Date: 19-Dec-2025
Our Ref: 2025/93365

**Application for a non-material amendment following a grant of planning permission,
Town and Country Planning Act 1990**

**Non material amendment to previous permission 2009/93382 for erection of retail
development
Cross Rink Street, Batley, WF17 6BH
Application Number: 2025/93365**

| DRG:<br>PROPOSED ELEVATIONS  |  |

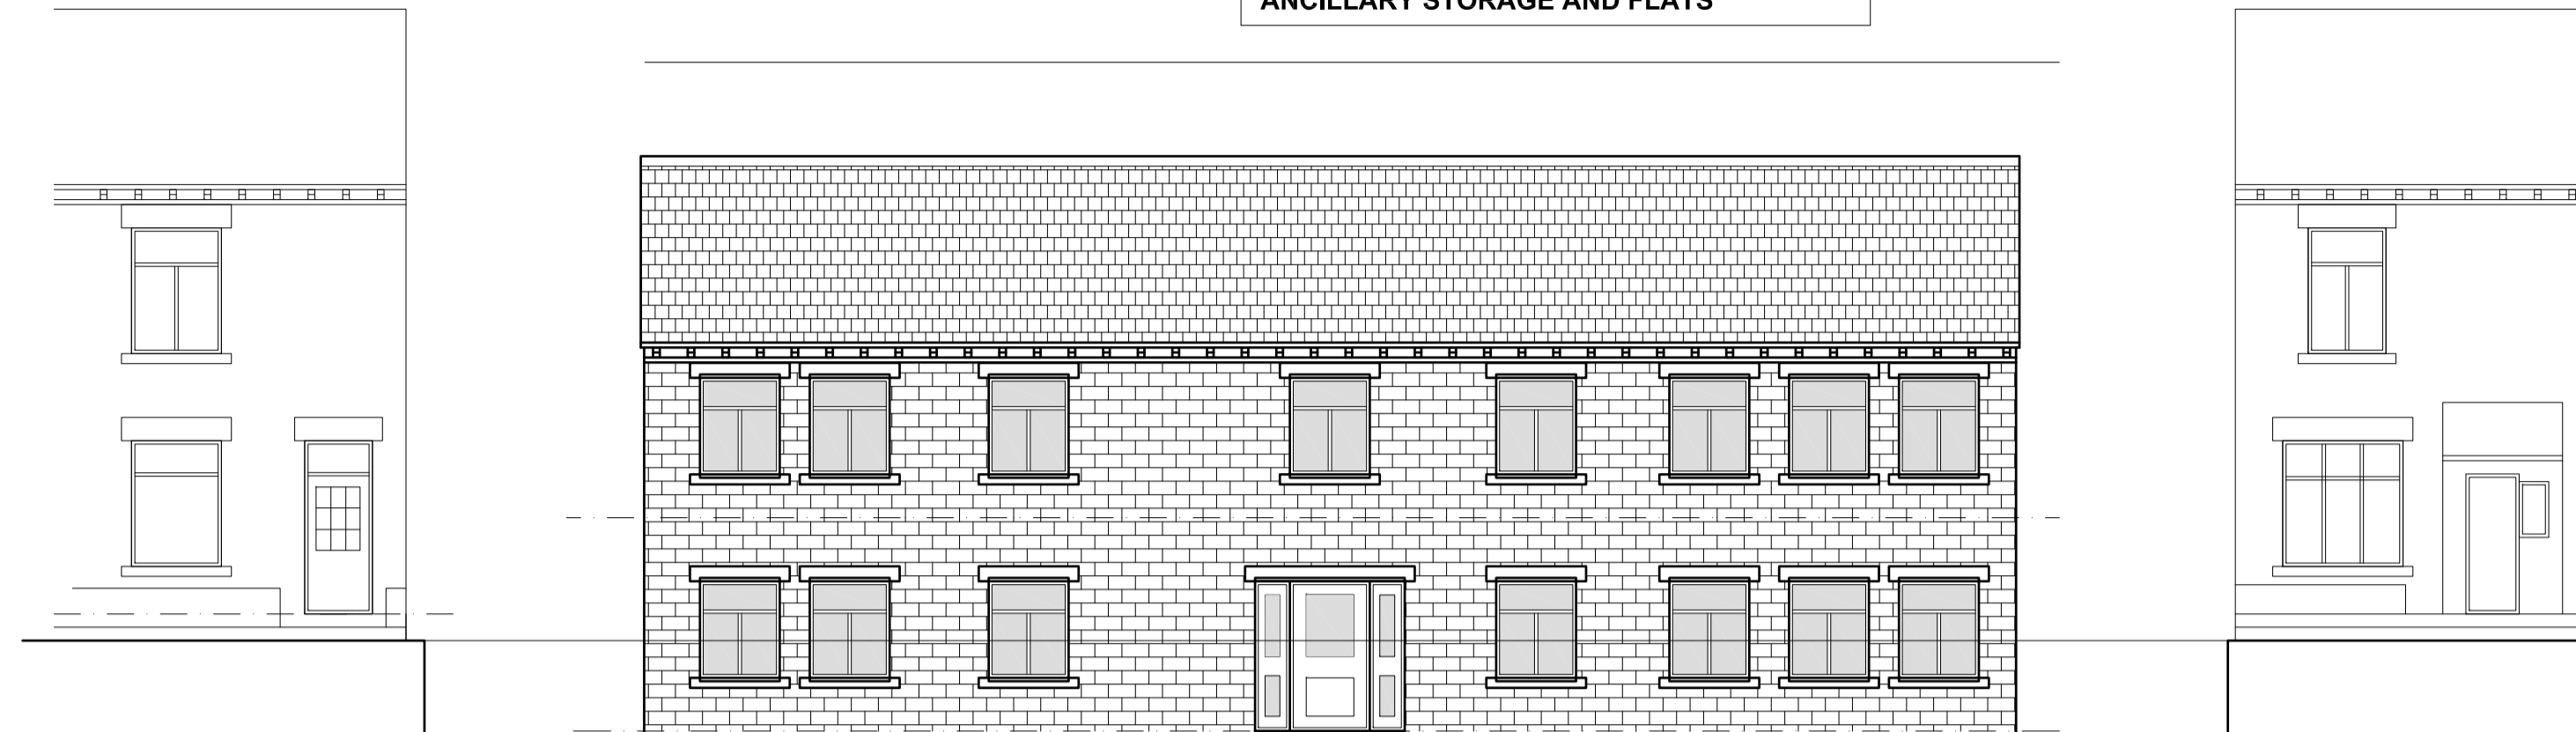
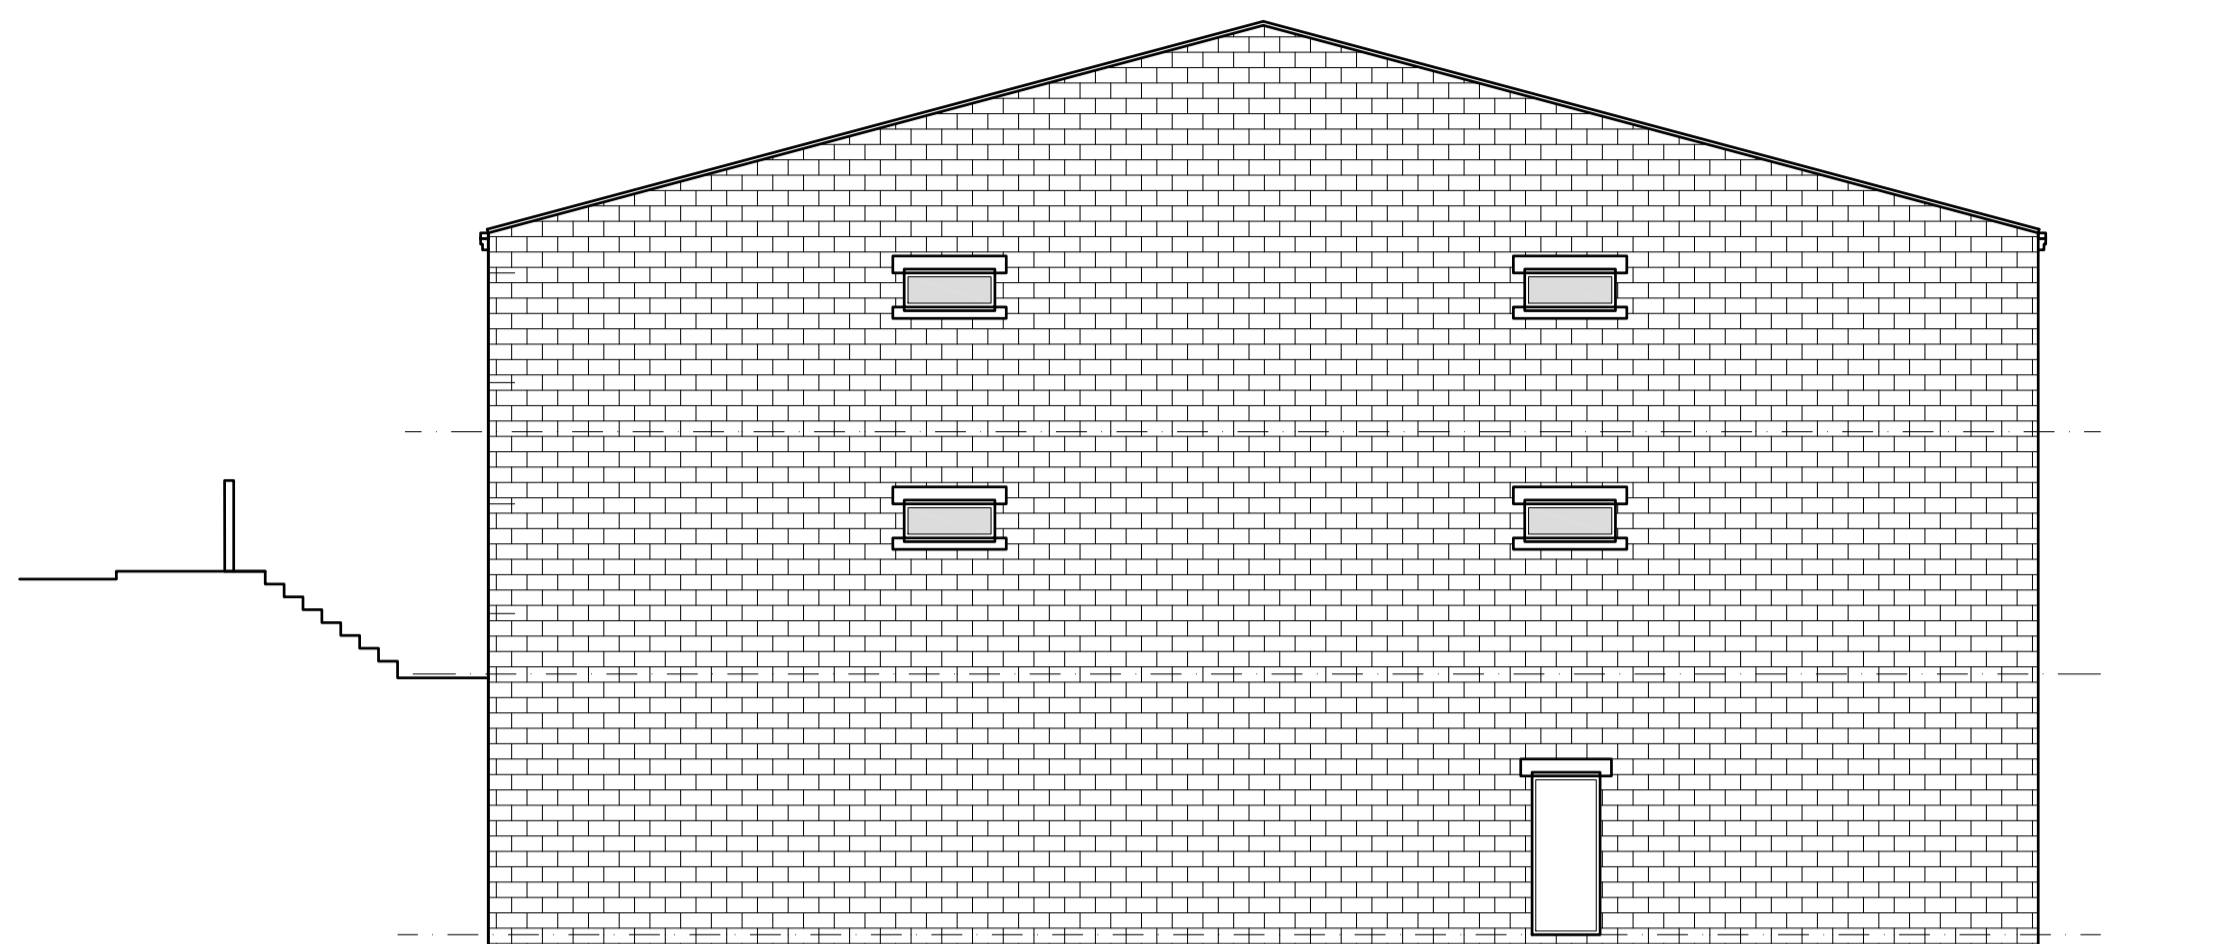
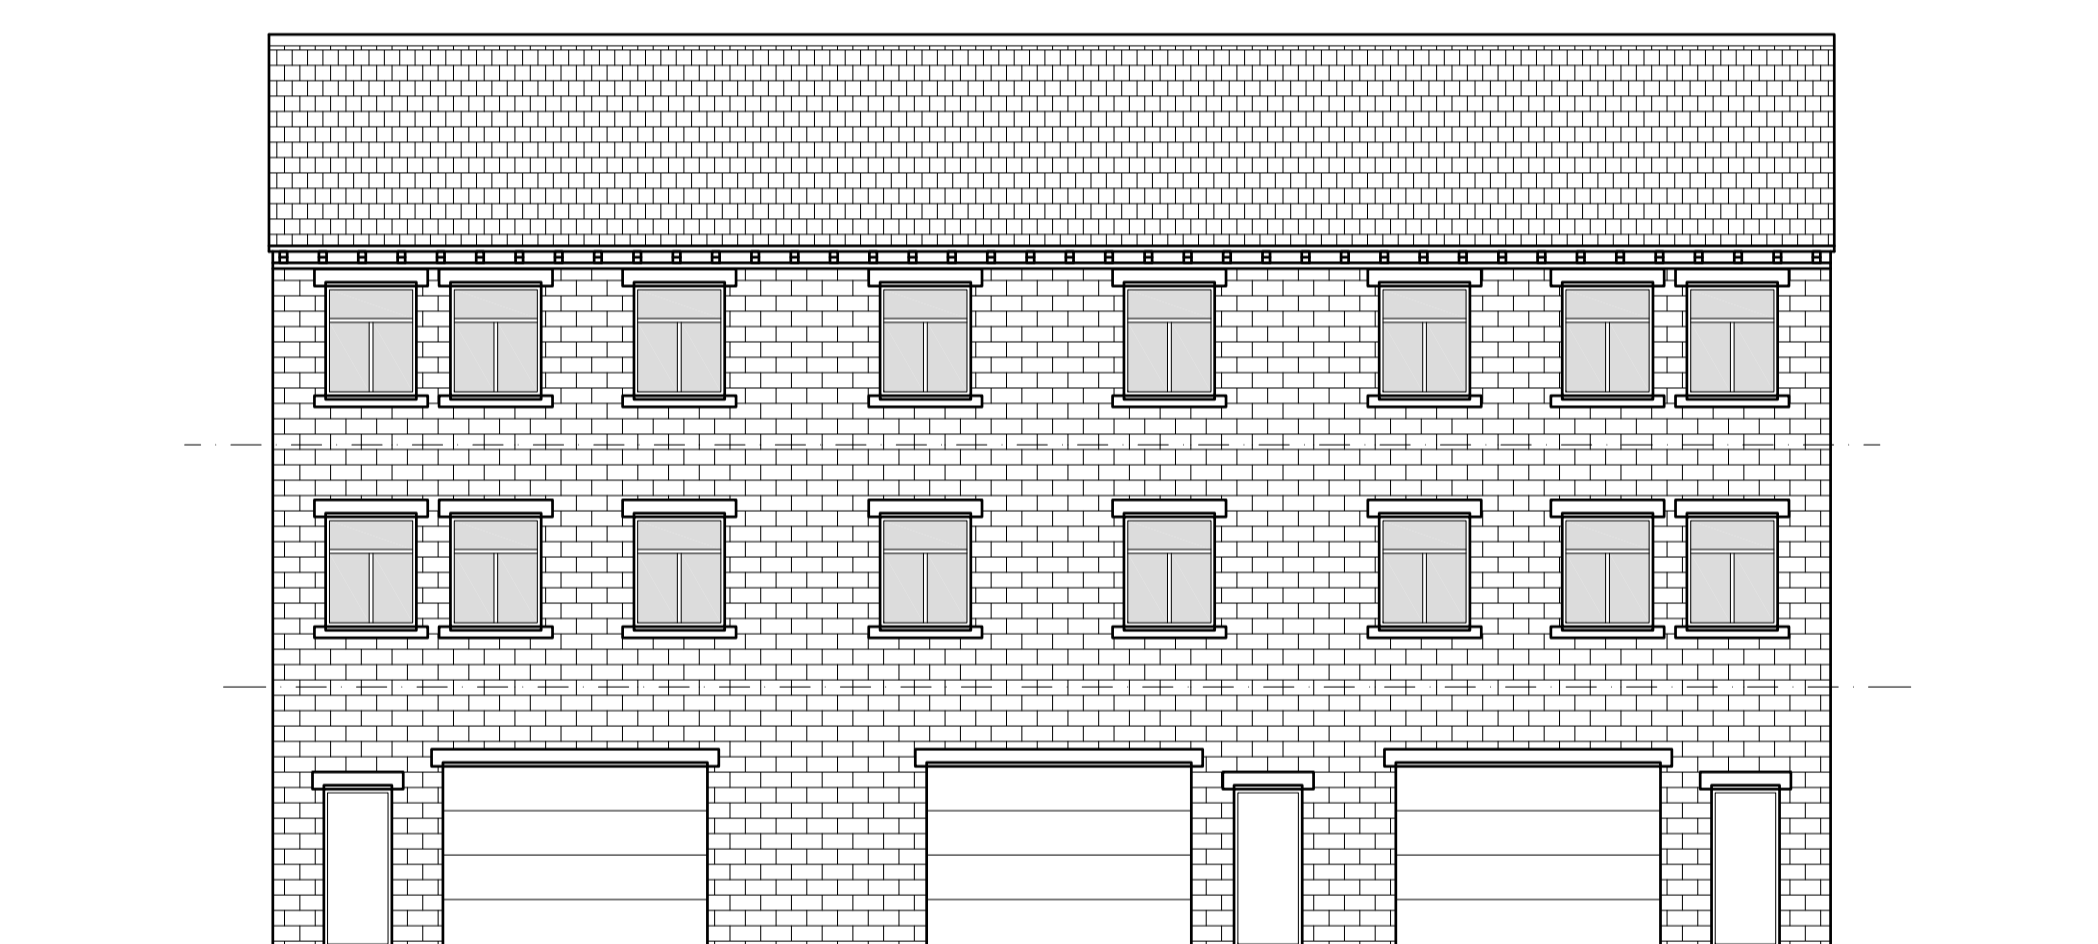
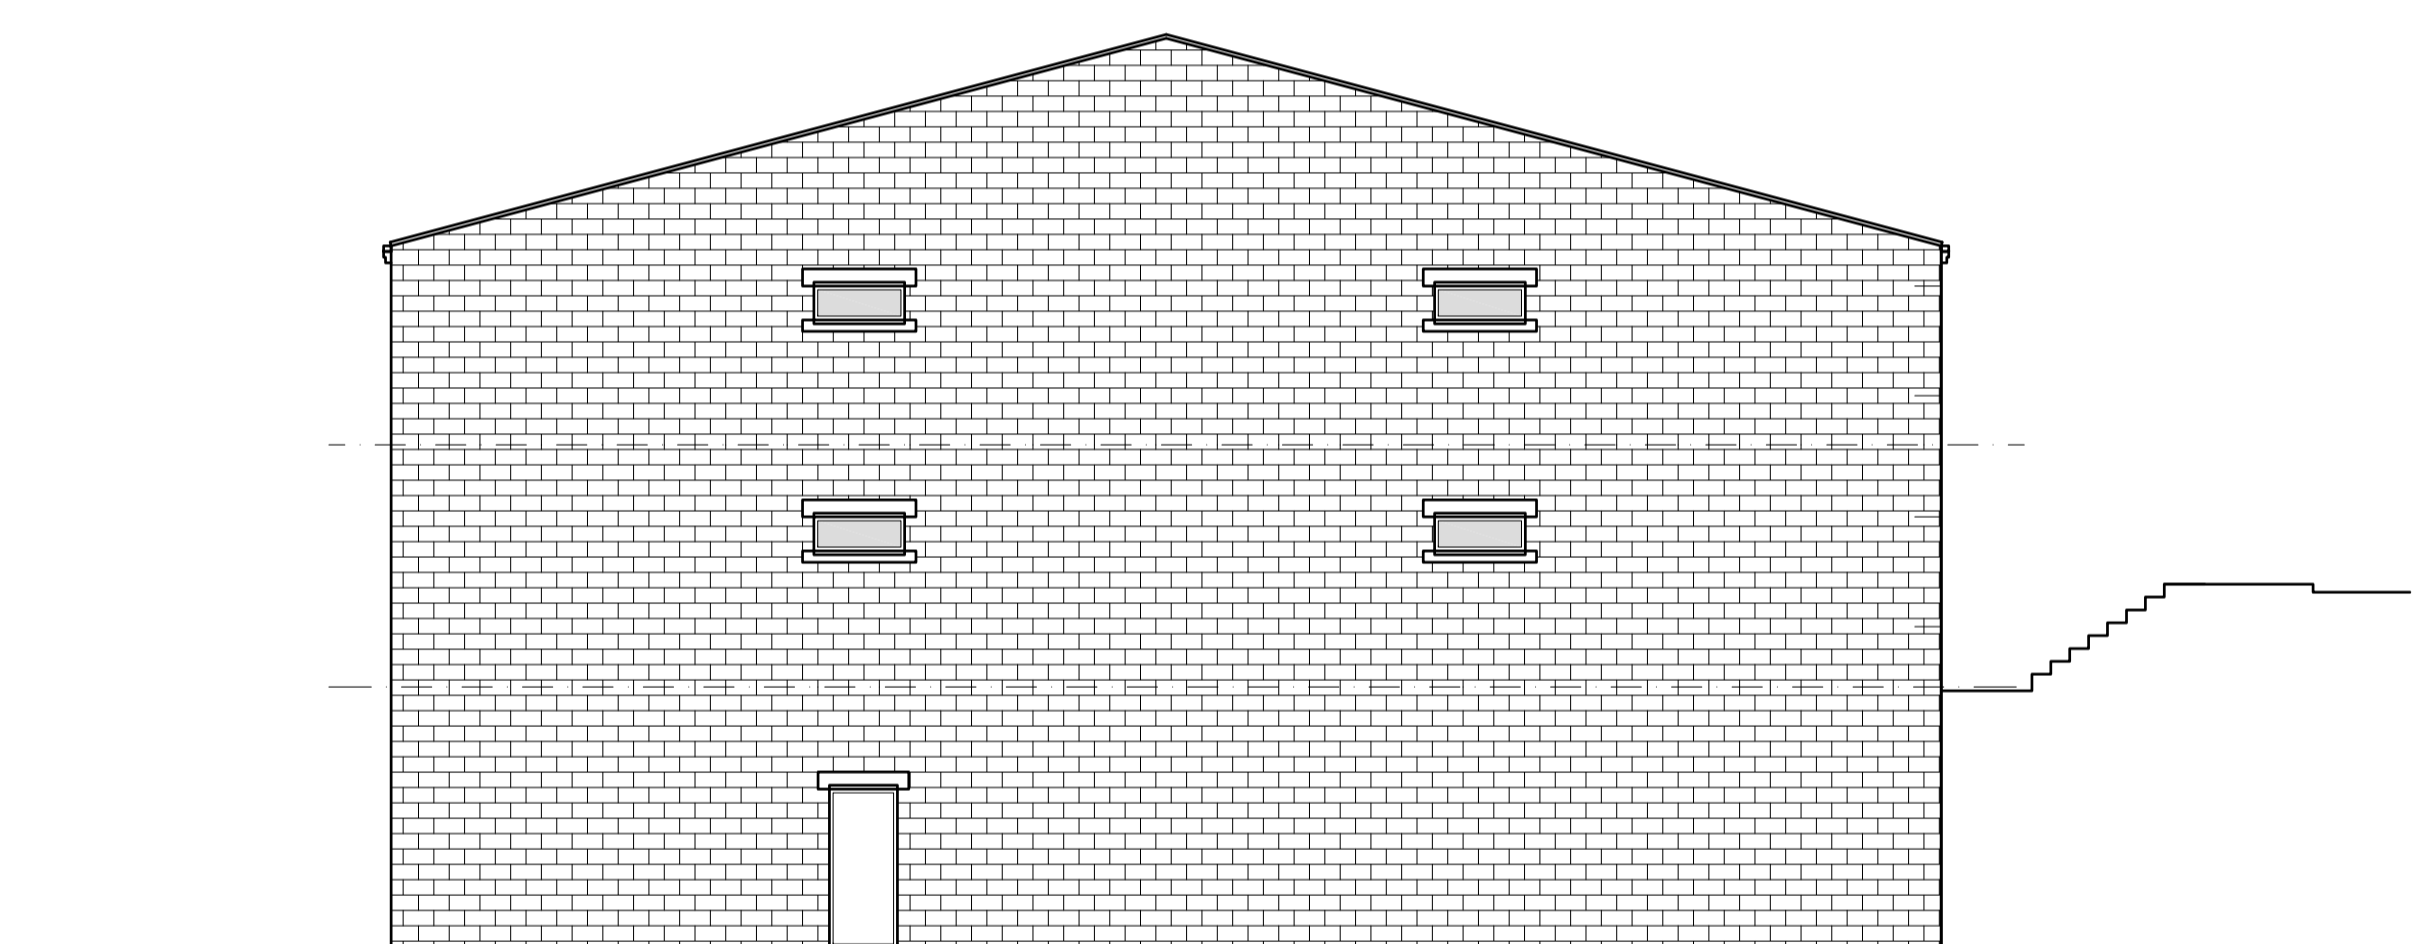
- Amendments to the originally approved structure to increase its height by around 0.7m.
- Changes made throughout the external elevations in terms of the design, window and door arrangements.
- No details have been provided in respect of materials and therefore Officers cannot confirm whether these are to be as approved, or not.
- Alterations to the originally approved access with a smaller, gated entrance shown on the submitted block plan, than previously approved.
- Parking numbers have changed with an increase of 2 spaces, due to the loss of 2 originally approved disabled spaces.
- Finally, the overall use of the site is proposed to be changed from a retail unit with storage and staff facilities, to 10 flats and warehouse storage.

- Proposed Elevations, Drawing No. 24.2782.05, received 11/12/2025.

I am only able to consider non-material amendments to plans approved under a previous planning permission which are minor and do not materially change the appearance or character of the previously publicised scheme. The proposed alterations to the approved plans extend beyond this, hence I can confirm that the proposed alterations as outlined above cannot be accepted to form a non-material amendment to the original proposal.

The proposed changes to the permitted scheme would result in the development falling outside of the description of the development as set out on the decision notice. This, in addition to the level of changes proposed to the internal and external elevations and layout of the site, are considered to be material in nature.

The application for a non-material amendment is hereby refused.
